From: Adderbury Parish Council Clerk <adderburypc@hotmail.com>
Sent: 19 May 2022 18:41
To: Planning <Planning@Cherwell-DC.gov.uk>
Subject: 22/00959/REM - OS Parcel 9100 Adjoining And East Of Last House Adjoining And North Of, Berry Hill Road, Adderbury

Adderbury Parish Council has no objections to the above application, however it makes the following comments:

BERRY HILL ROAD, ADDERBURY - DRAFT SITE LAYOUT

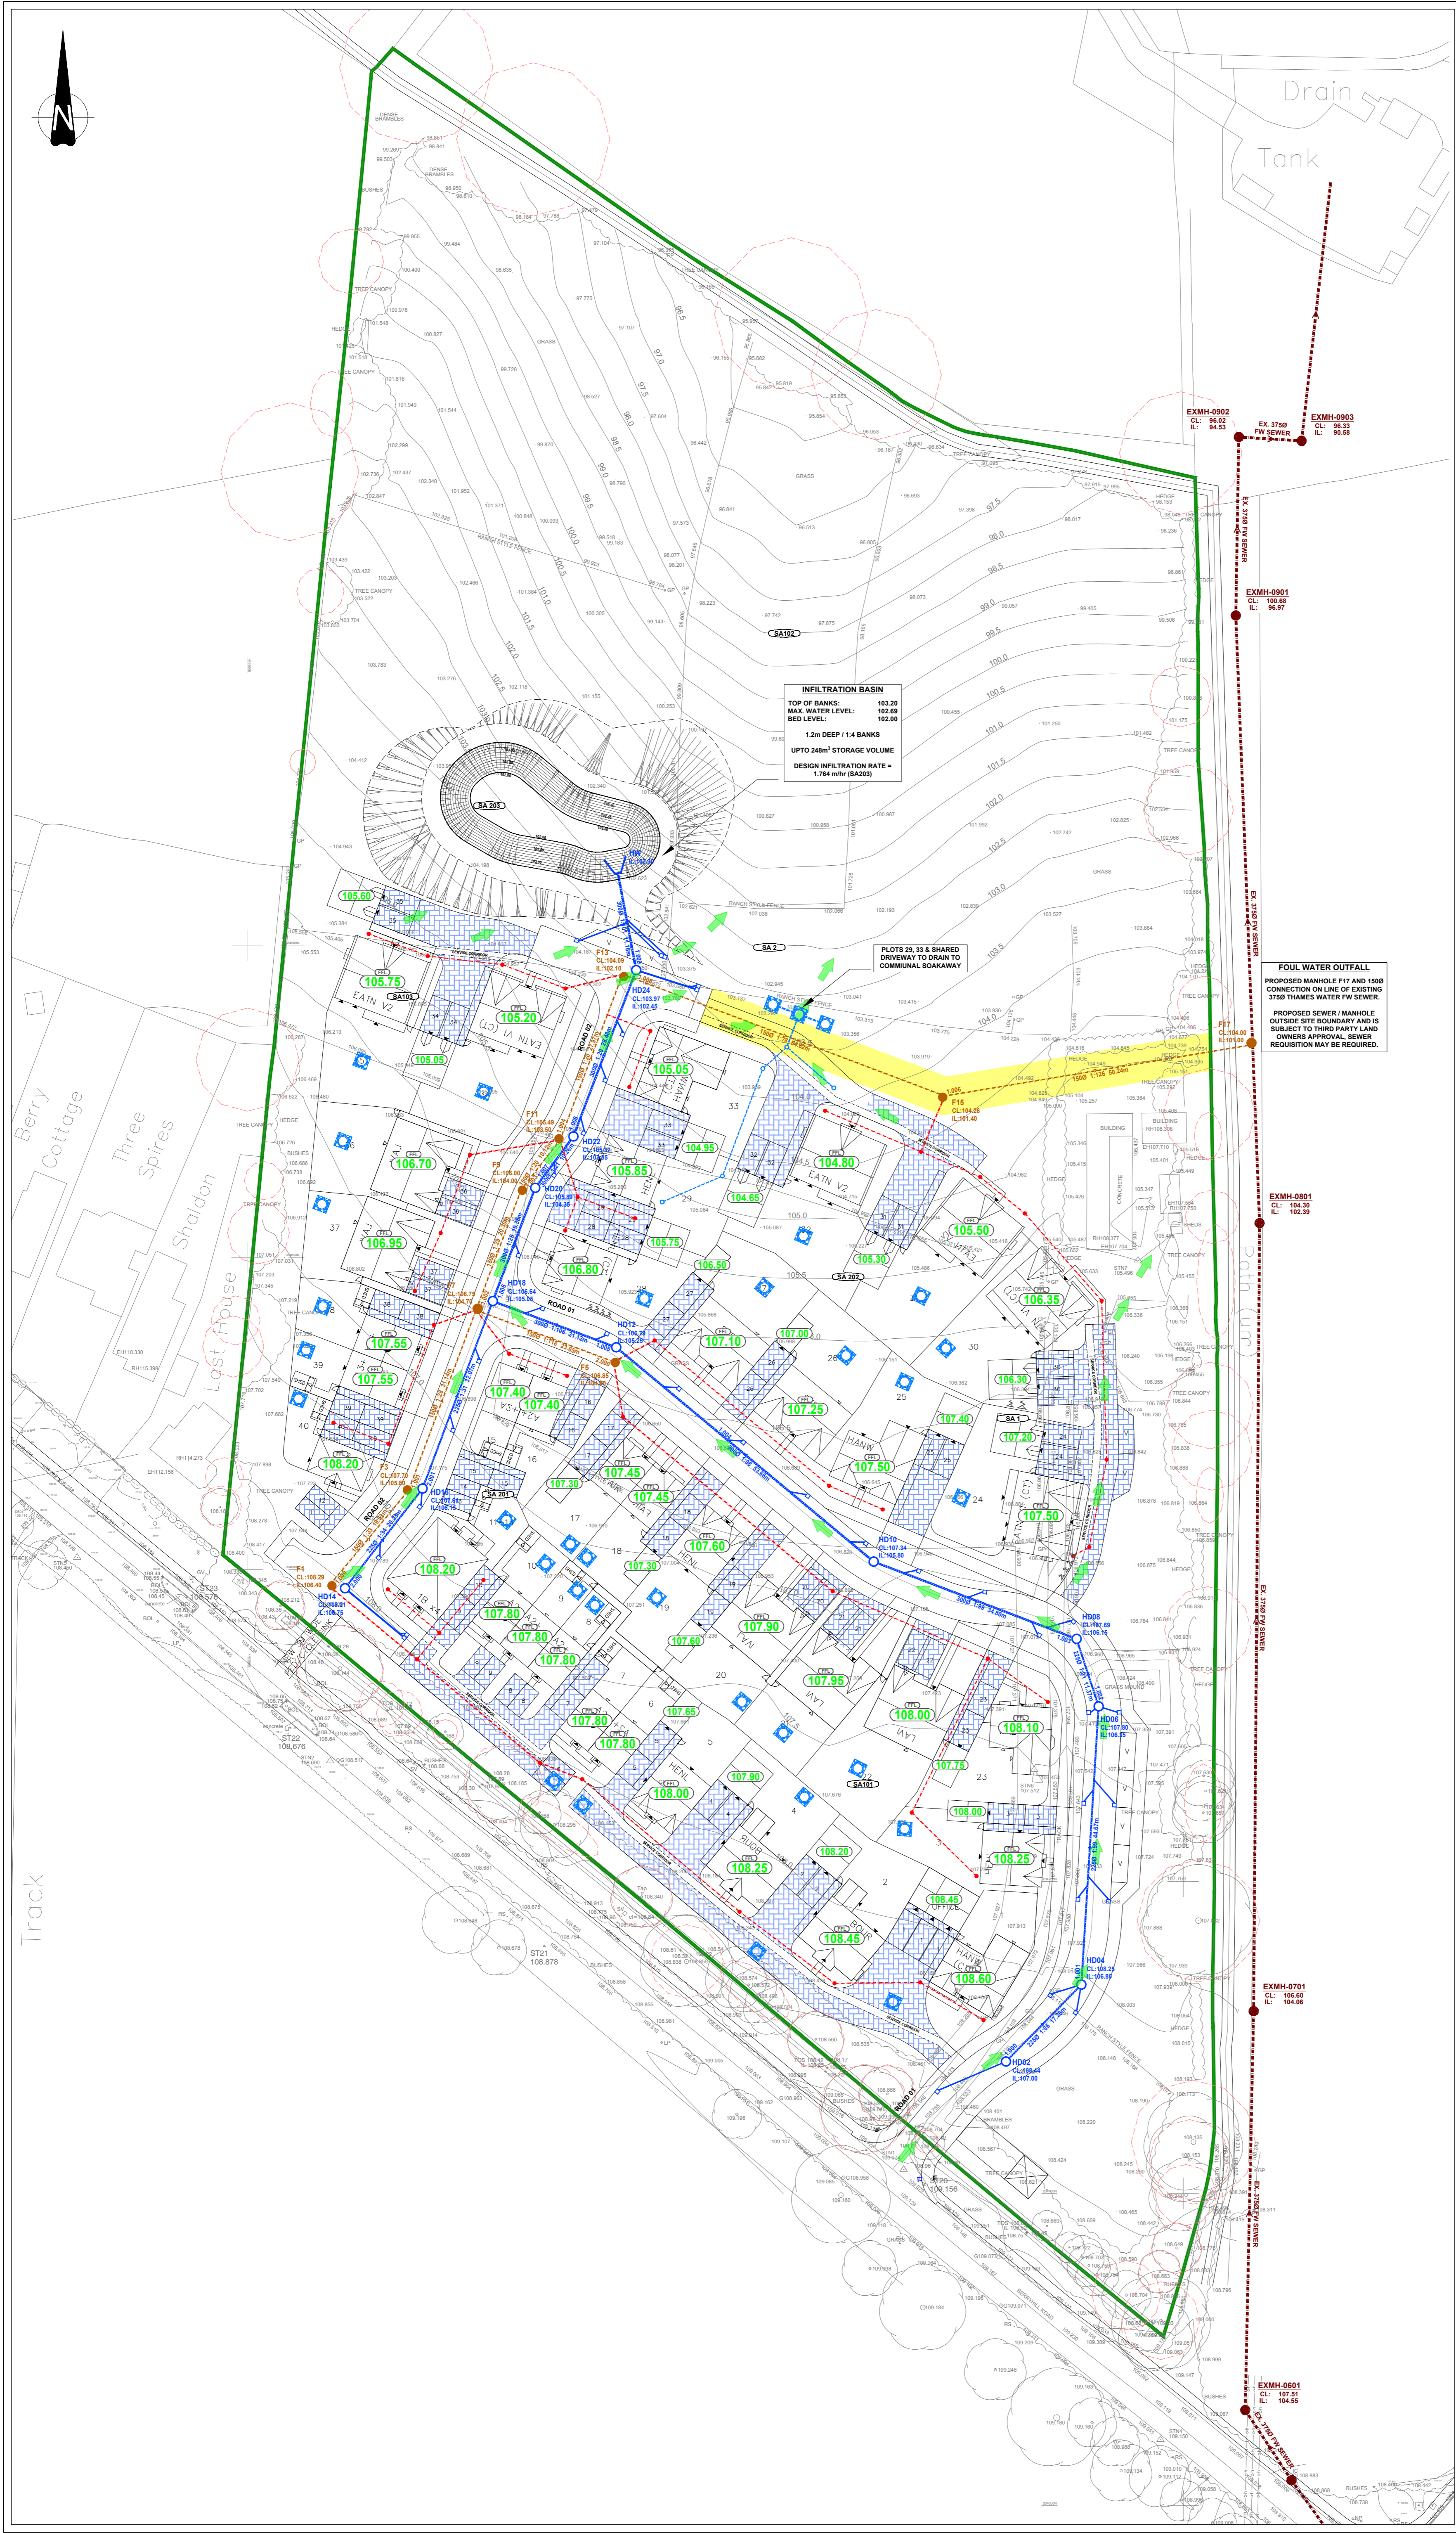
- 1.The houses must not be built using reconstituted stone. Natural stone should be used.
- 2.There should be more landscaping and shielding between Last House and Shaldon on Berry Hill Road and the houses on the new development's west boundary.

- 3.Residents of Sheldon and Last House should not lose their view of St Mary's Church so repositioning of the 5 bedroomed property is requested, perhaps being swapped with a less 'imposing' lower height property.

- 4.There needs to be a bigger gap between Shaldon and Last House and the houses on the development.
- 5.Affordable housing should be allocated to those from Adderbury or those with a strong connection to the village. It should also be integrated around the development and not located all in one area of the site. Some affordable houses appear to be allocated at the south west corner of the site. As these are often family homes, the PC would like to see these moved to nearer the play area/amenity open space so that children can play out while being supervised. The Bloor Homes development on Aynho Road, Adderbury is a successful example of this.

7. The entrance to the development and the layout of the houses should not be changed and be in accordance with the decision of the Planning Inspector. The Parish Council believes the green space to the east of the development forms a good, natural edge to this extension of the village.
